Our ref: HA/2019/121210/01-L01
Your ref: EP/180/18/PL
Date: 09 April 2019

CHANGE OF USE OF BOAT STORE & SAIL LOFT (SUI GENERIS) TO A SINGLE RESIDENTIAL DWELLING (C3 - DWELLINGHOUSE) & PART CHANGE OF USE OF FORMER DINGHY PEN TO CARAVAN SITE (SUI GENERIS)

BUILDING WEST OF 131 SEA ROAD EAST PRESTON BN16 1PD

Environment Agency position

TITLE Topographical Survey	
SCALE 1:500 @ A3	DRG. No. 3

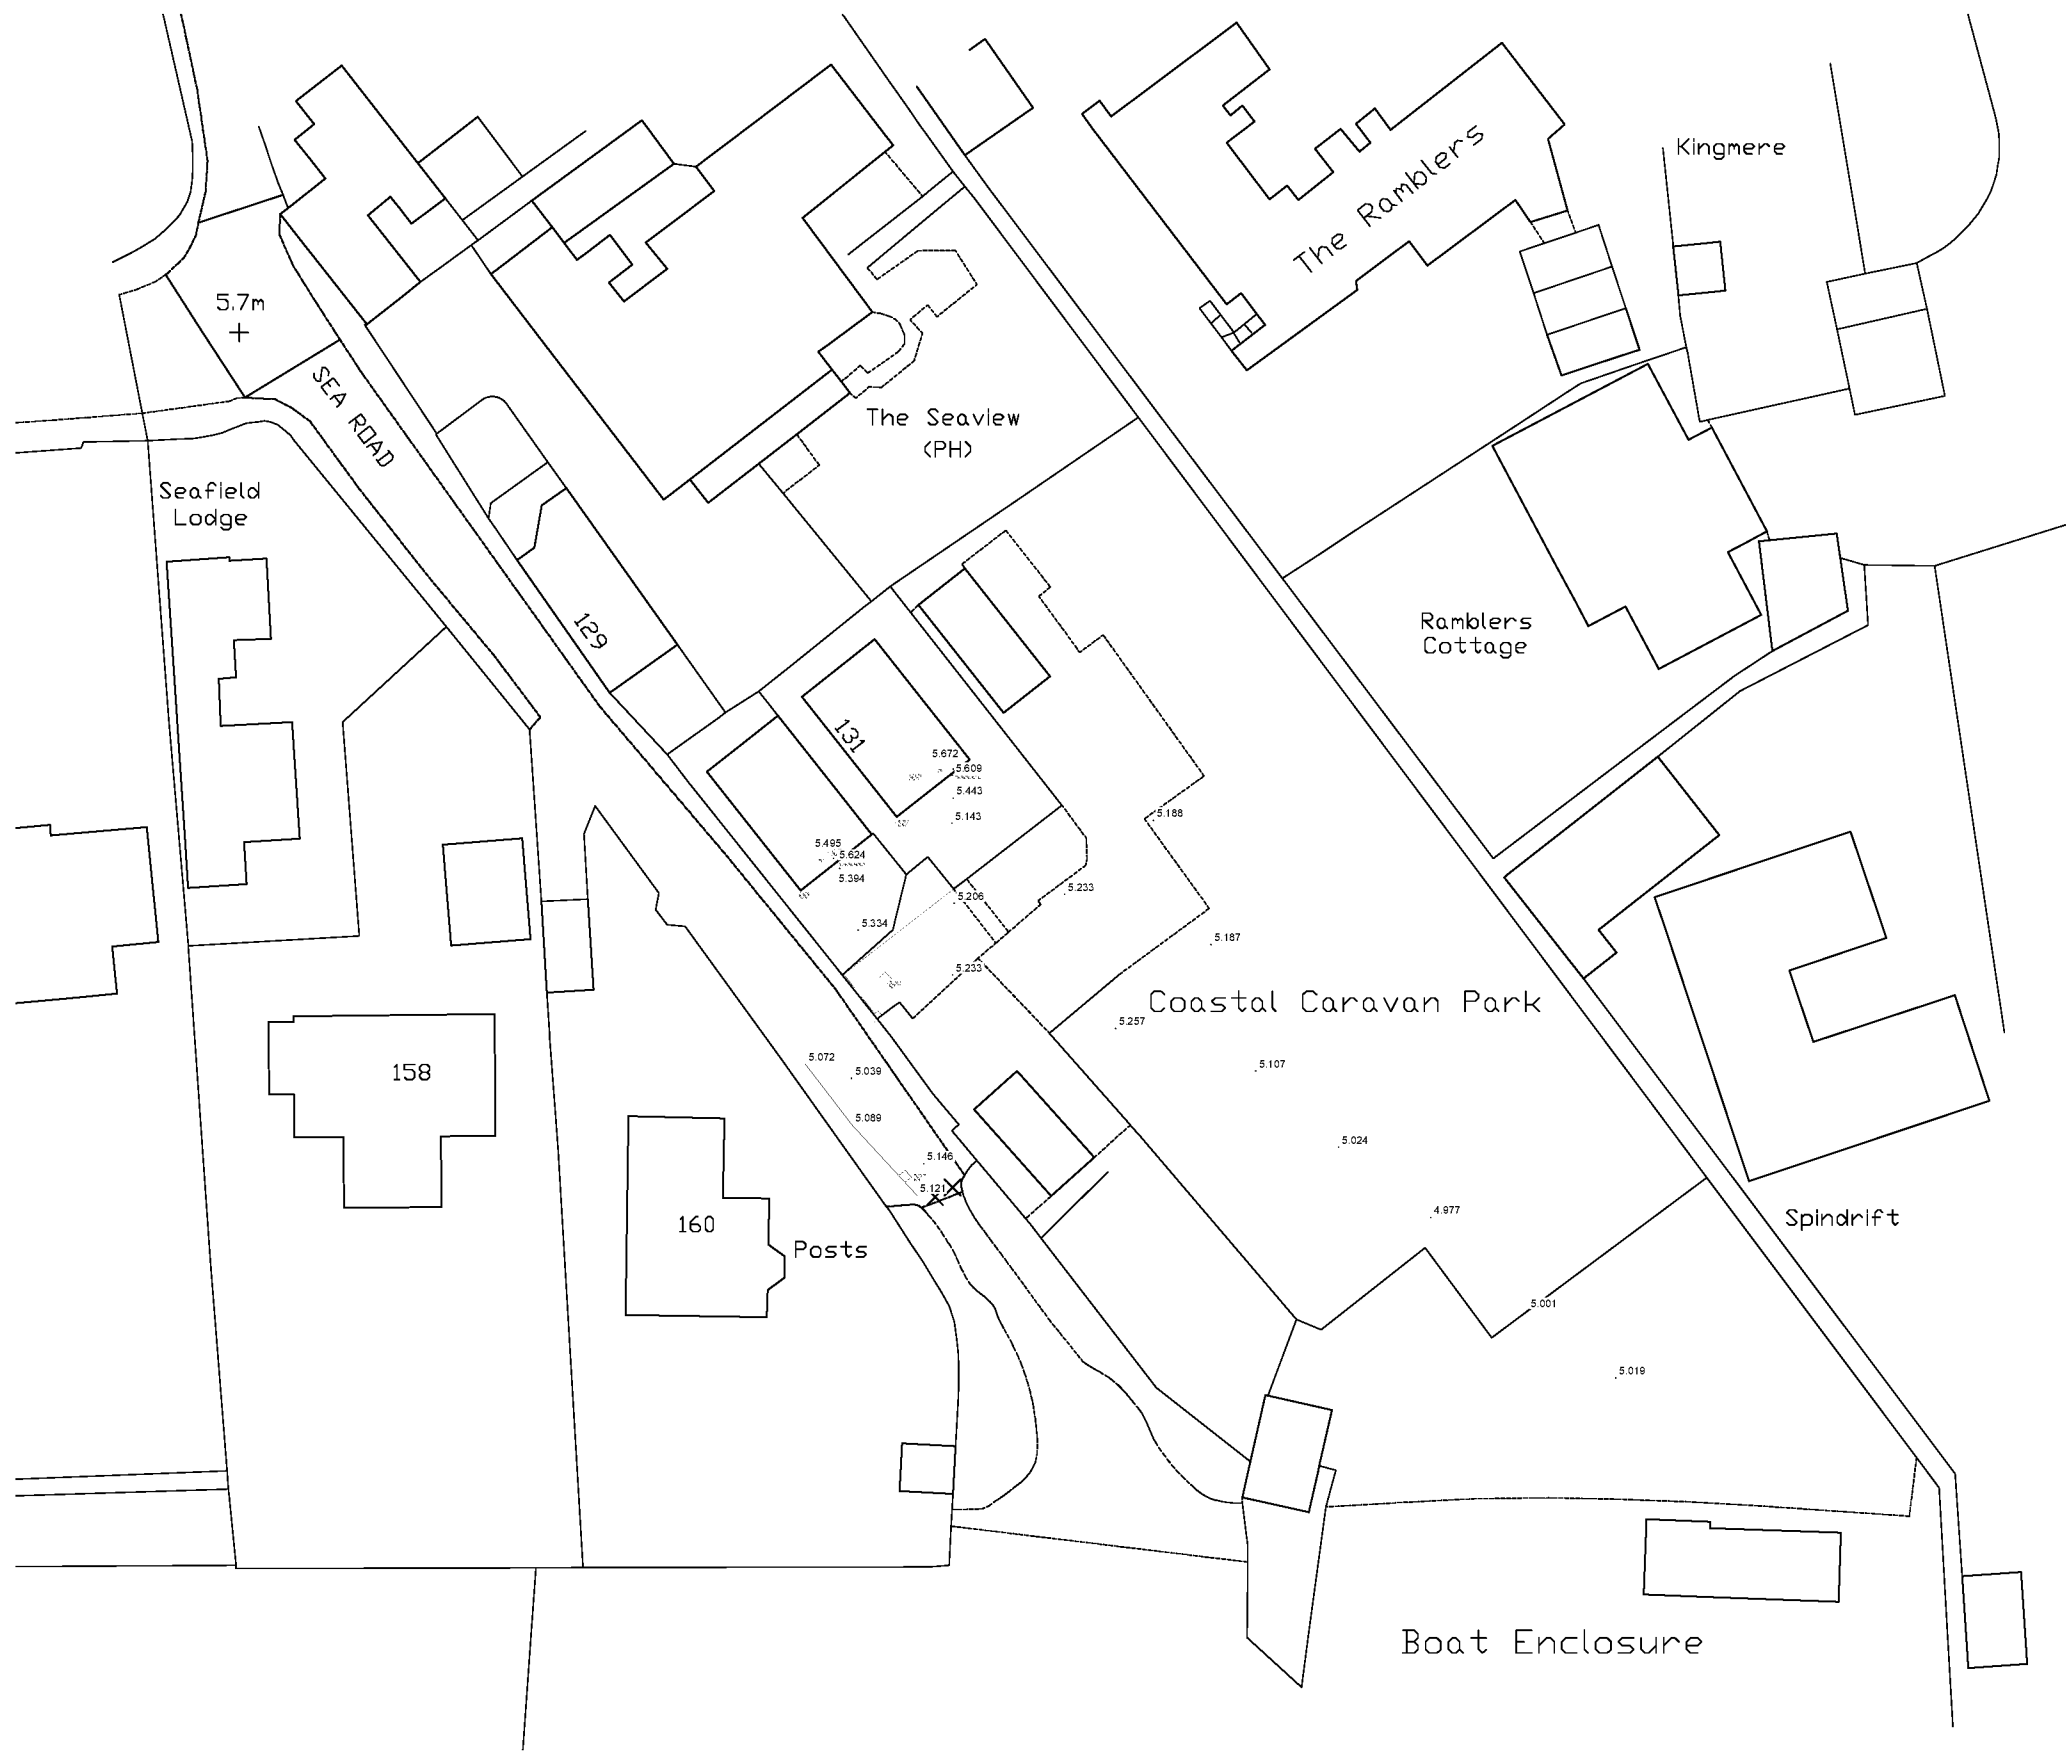
1. Provide details of the topographical levels survey, in order to provide evidence that the finished floor levels are above the 0.5% AEP (Flood Zone 3) and 0.5% AEP 2115, as stated in the FRA.
2. Provide details of the change of use for the proposed new caravans, in particular regarding flood risk vulnerability classification, time occupancy, appropriate flood mitigation measures.
3. Consider the requirement for flood emergency planning including flood warning and evacuation of people for a range of flooding events up to and including the

To overcome our objection, the applicant should submit a revised FRA which addresses the points highlighted above.
